GREATER LONDON AUTHORITY

Deadline 3 - Sheet 4: GLA commentary on other documents prepared by the Applicant for Deadline 2

1:24,000 @ A3	Electrical Connection Refined Application Boundary
16/05/19	
Drawn: HG	
Checked: RG

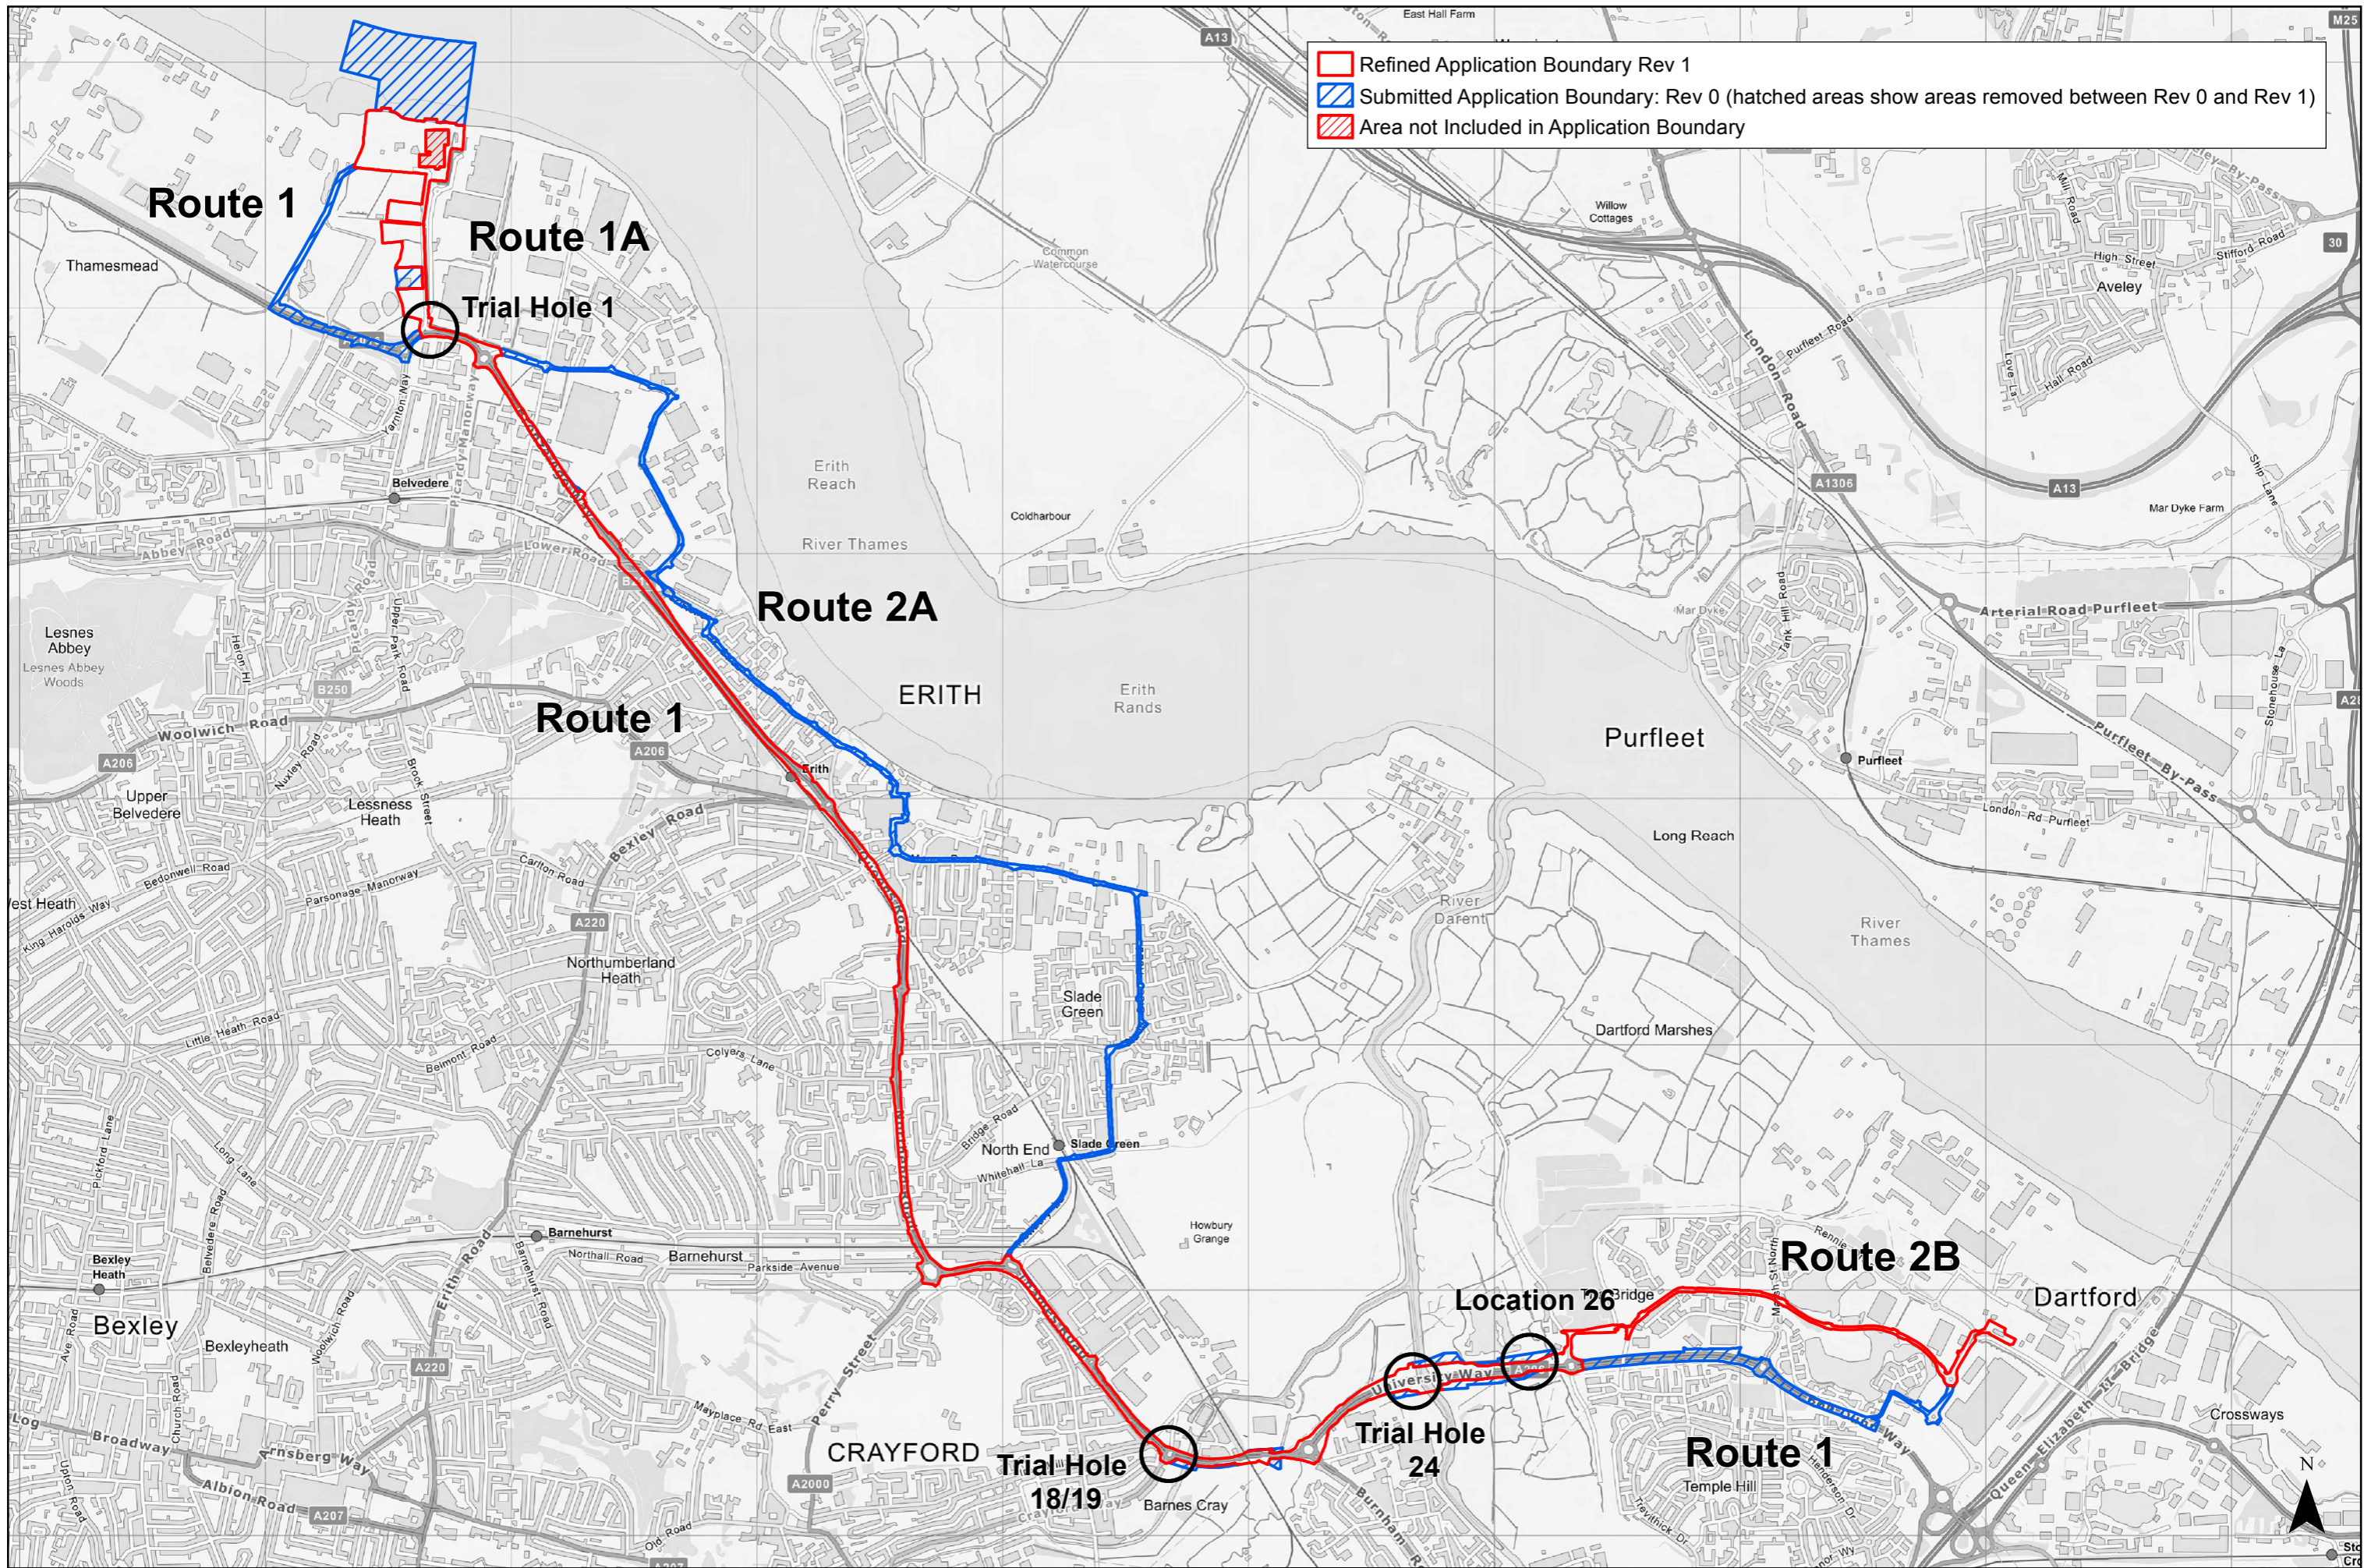
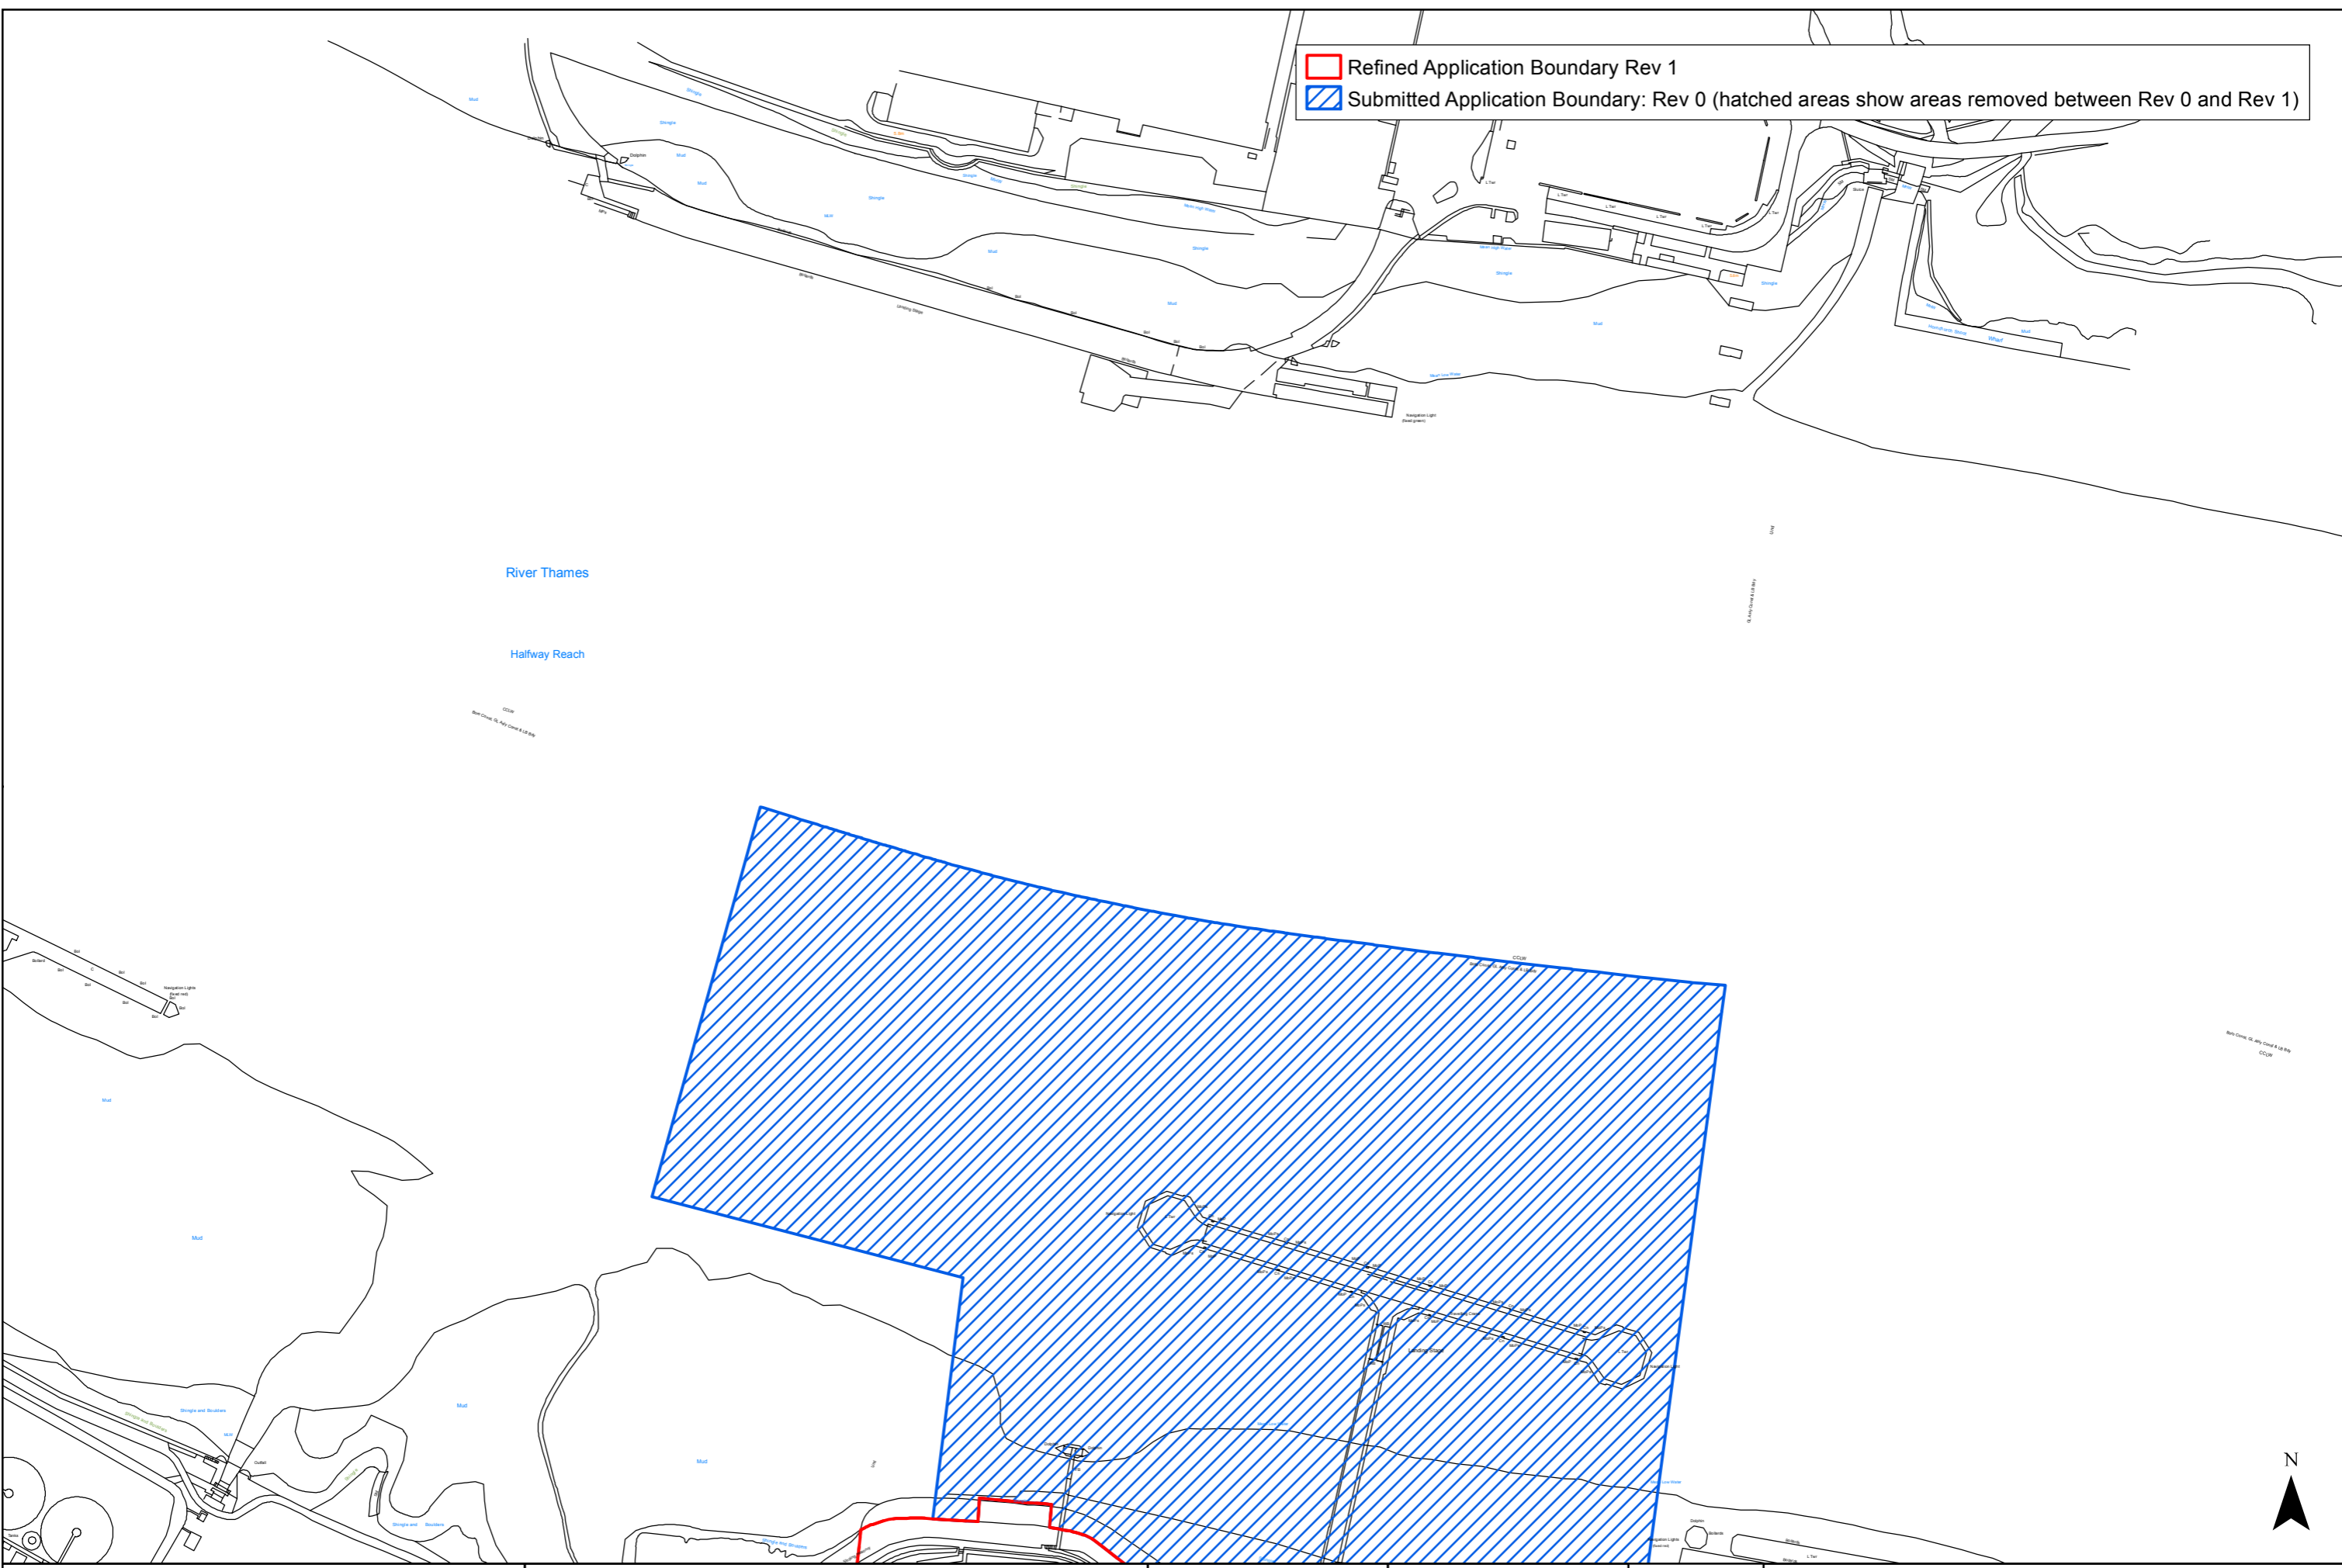
8.02.07 Electrical Connection Progress Report		
Connection route now selected	Additional assessment to determine quantifiable impacts of the Electrical Connection	The Applicant has set out the selected Electrical Connection route, which mostly follows the Strategic Road Network between the REP site and the Littlebrook Power Station. This route is expected to have a lesser impact on buses than the alternative route shown at the time of the submission of the application, however several bus routes will still be affected by the construction activities. This is set out visually in the figure below:

Item	Issue / action	GLA/TFL response
	<p>construction on buses.</p>	 <p>The map displays the River Thames flowing through the Bexley Heath area. A prominent yellow line, representing the 'ELECTRICAL CONNECTION', runs north-south through the center of the map. A network of red lines, representing 'BUS ROUTES', is overlaid on the map, showing various paths that cross the yellow line at several points. Key locations labeled include Bexley Heath, Erith, Crayford Marshes, and Rainham Marshes. A legend at the bottom of the map area identifies the yellow line as 'ELECTRICAL CONNECTION' and the red lines as 'BUS ROUTES'.</p> <p>The figure above shows that bus routes are expected to cross over the Electrical Connection route at several points via junctions and some bus routes would still run along the Electrical Connection</p>

Item	Issue / action	GLA/TFL response
		route. The impact of construction on these routes should be fully assessed by the applicant so that TFL and bus operating companies are able to propose mitigation based on the likely level of delay to the bus routes.
